Application no: 16/00472/OUT-6

Location: S Grundon Services Ltd, Merton Street, Banbury

Transport Schedule

# 11 | Vehicle Movement

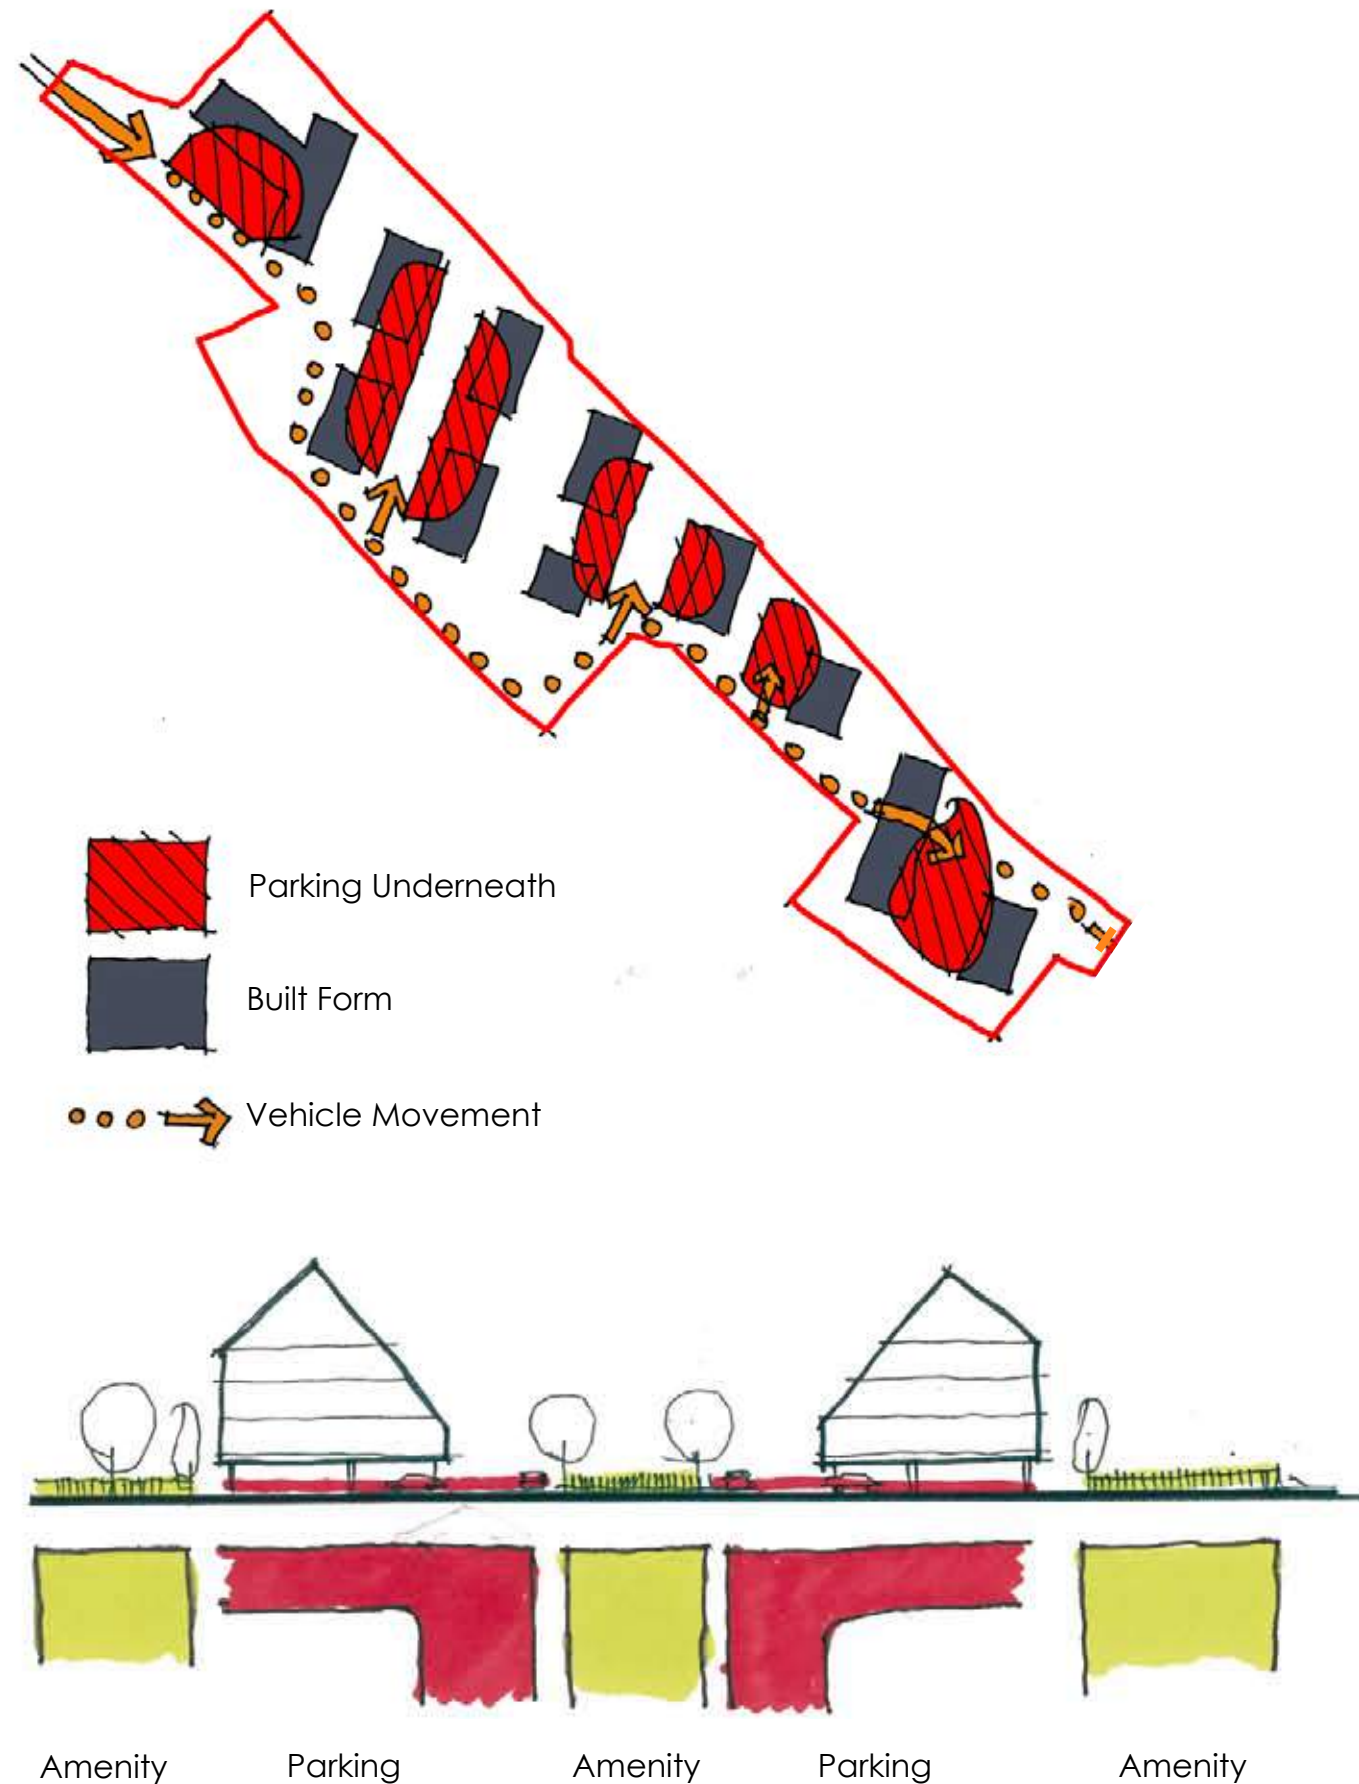
One such change is that, since this application was first submitted, the county council has adopted its Cycle Design Standards, which require a higher standard of cycle provision than that provided for in the proposals for the link road through the development. Due to the fact that this will become a connecting road between the town centre and a major employment area, there are likely to be high volumes of pedestrians and cyclists using the road, as well as a substantial volume of car traffic. It is therefore vital to provide sufficient space to accommodate cyclists and pedestrians without the risk of conflict.

We would be prepared to accept pedestrian and cycle facilities on one side of the road only for much of the length of the road, but there needs to be a separate footway (2m) alongside a 3m cycleway, as well as a separating strip between the cycleway and the carriageway. This will add to the width of the corridor, but we consider it is a required level of provision given this central location and the importance of the link.

We would accept dedication of the additional land for the separate footway, pending the connection of the link road.
